**Application** H14-1200-22  
**Location** NORTHGATE HOUSE NORTHGATE PINCHBECK PE11 3SQ  
**Proposal** Change of use of land to B8 storage and distribution - retrospective

**Name** Black Sluice Internal Drainage Board  
**Address** Station Road Swineshead Boston PE20 3PW

**Date Submitted** 09-01-23  
**For/Against** Comments

Drawing Title			 enquiries@marksimmondsplanningservices.co.uk Mark Simmonds Director Mark Simmonds Planning Services Ltd Mercury House Willoughton Drive Foxby Lane Gainsborough DN21 1DY
			PROPOSED SITE PLAN NORTHGATE HOUSE, NORTHGATE, PINCHBECK			
Ref:		LIGM 002	Scale @ A3	1:750	Date	DEC/22

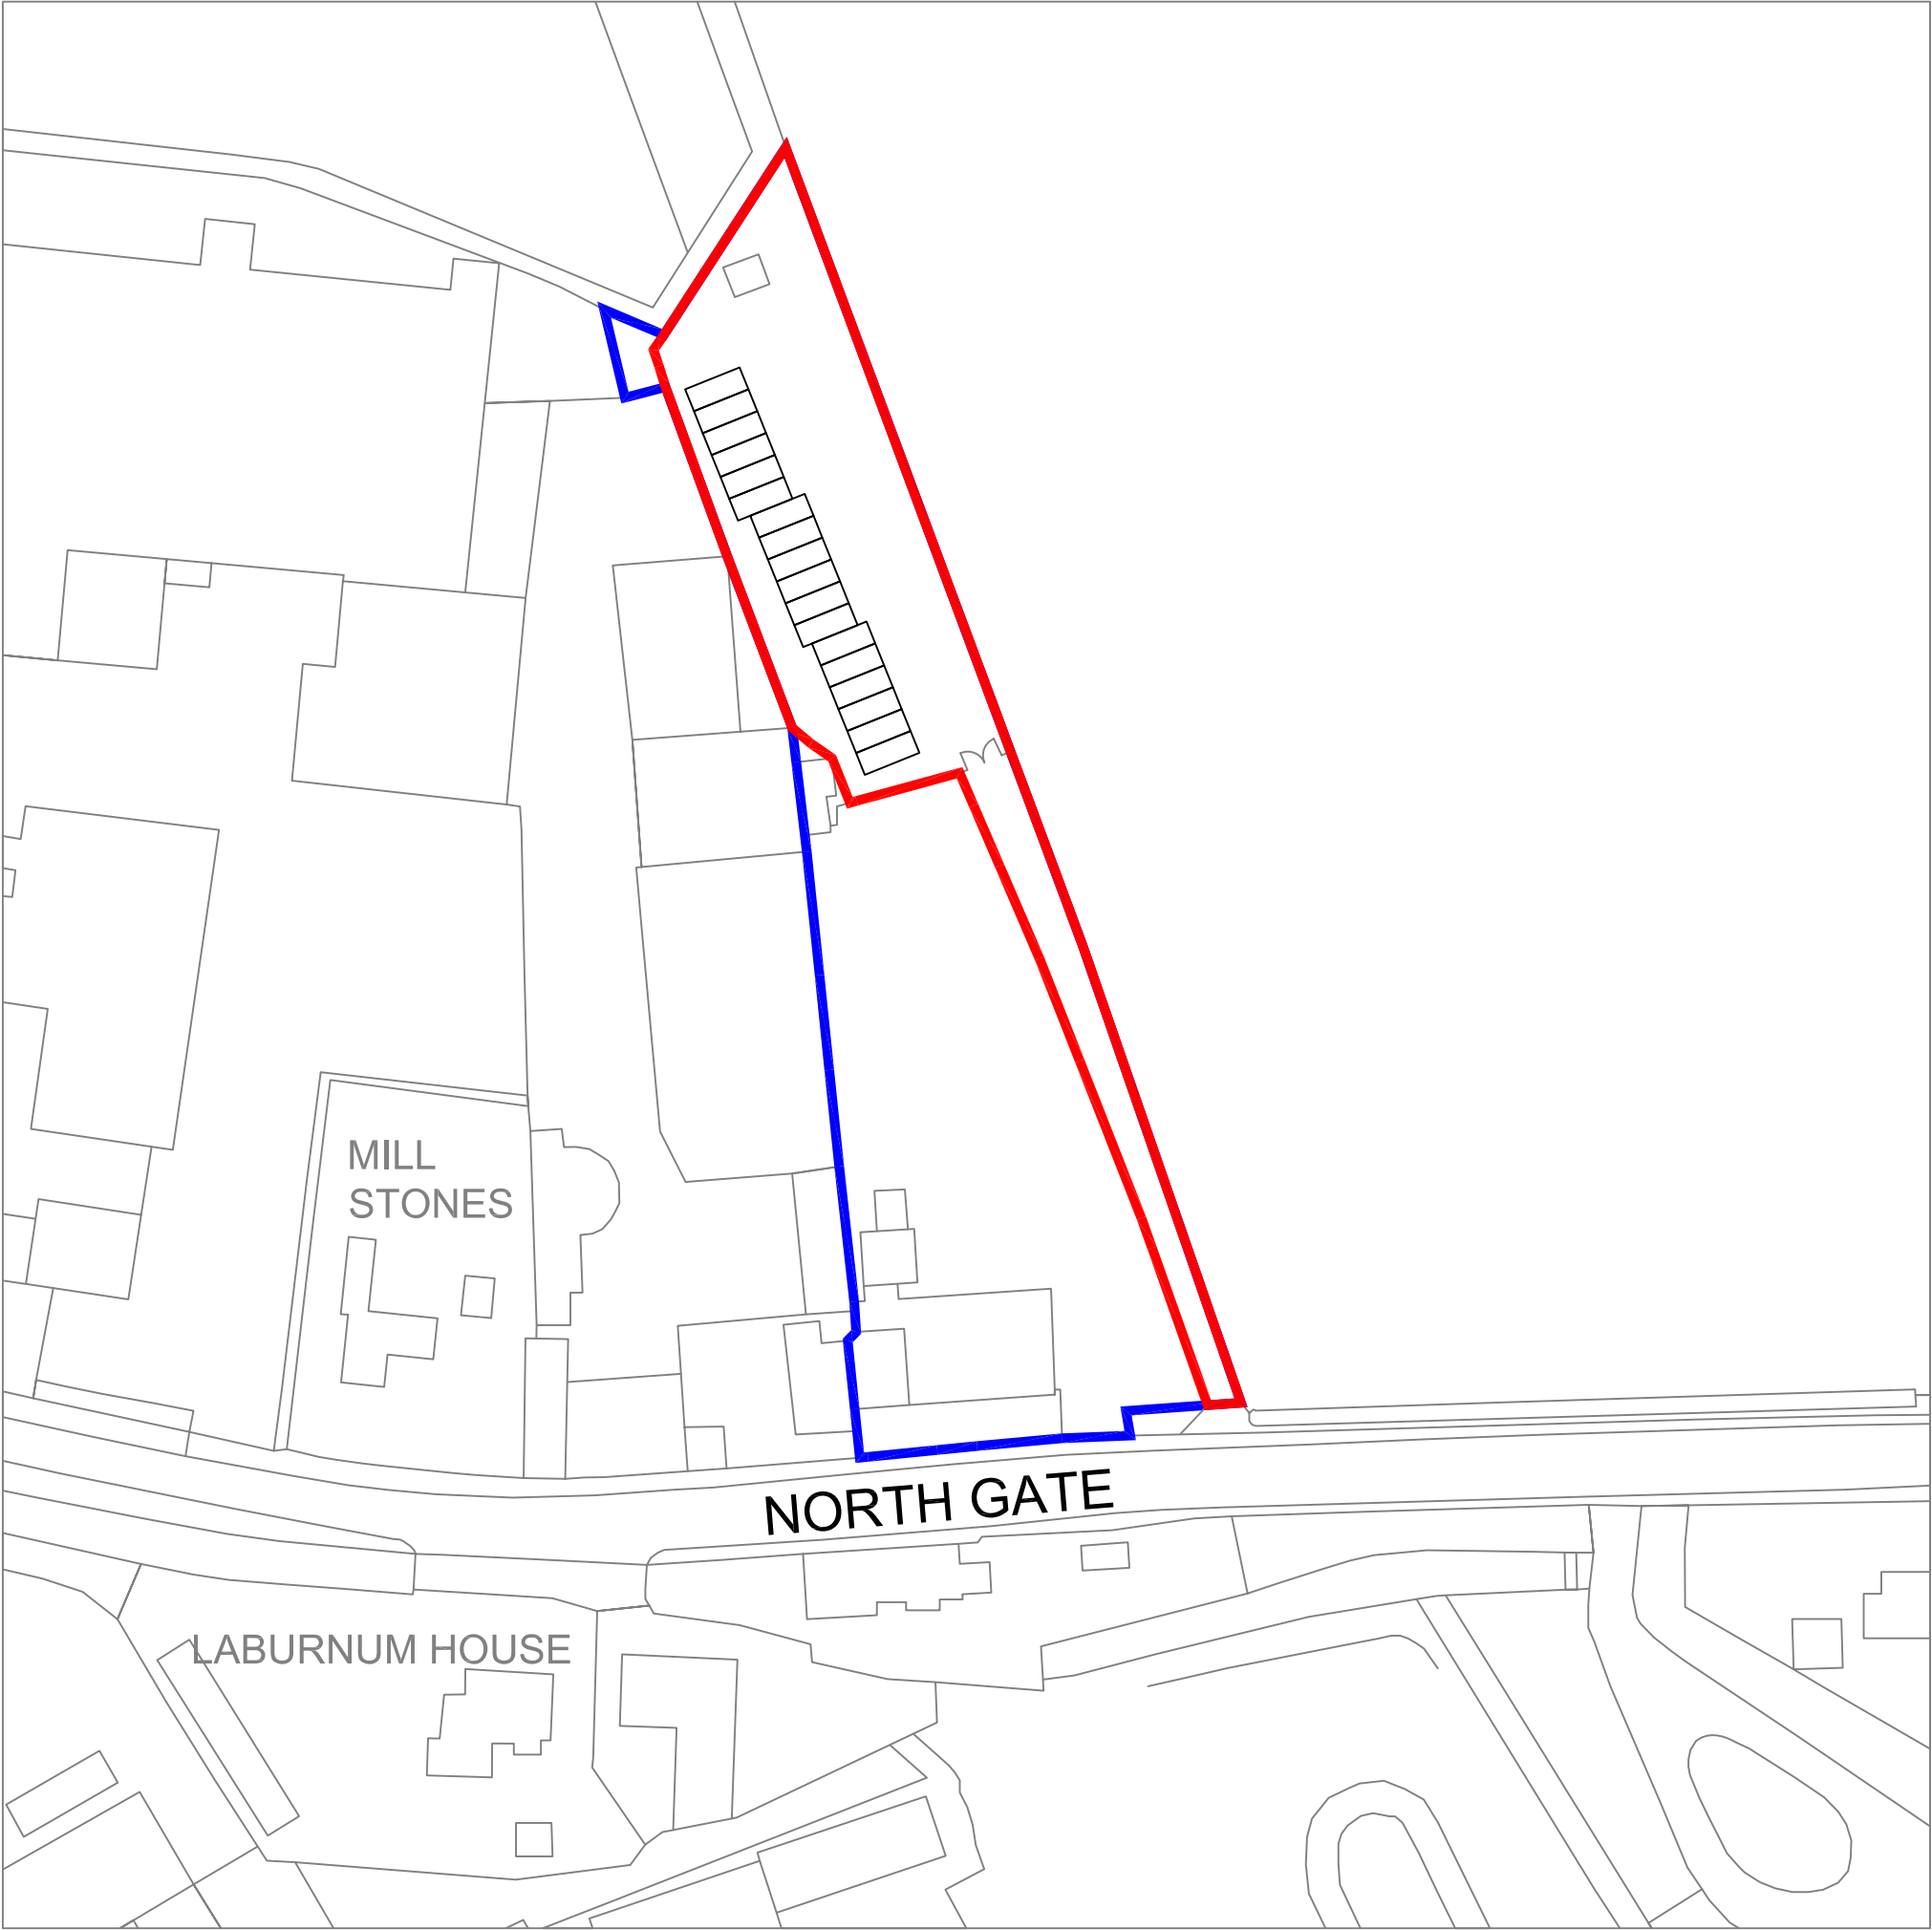
1. The applicant has indicated that a sustainable drainage system is to be used, this believed to be infiltration or soakaways. Provided the applicant has carried out suitable testing to ensure that such methods are suitable, then the Board have no further comments. However, if soakaways/infiltration are subsequently found to be unsuitable, then the applicant will be responsible for all damages caused to their own and any adjacent properties should flooding be caused by the development.

2. There is understood to be an open watercourse on the northern boundary. This watercourse is not owned or maintained by the Board. The applicant is reminded that within common law, they are responsible for the riparian ownership and maintenance for this and any other watercourses which may bound or cross the property concerned. If the applicant wishes to place any structures, such as piped culverts, within any watercourse, then they must obtain the prior written consent of the Board, as per Section 23 of the Land Drainage Act 1991. This is mandatory.
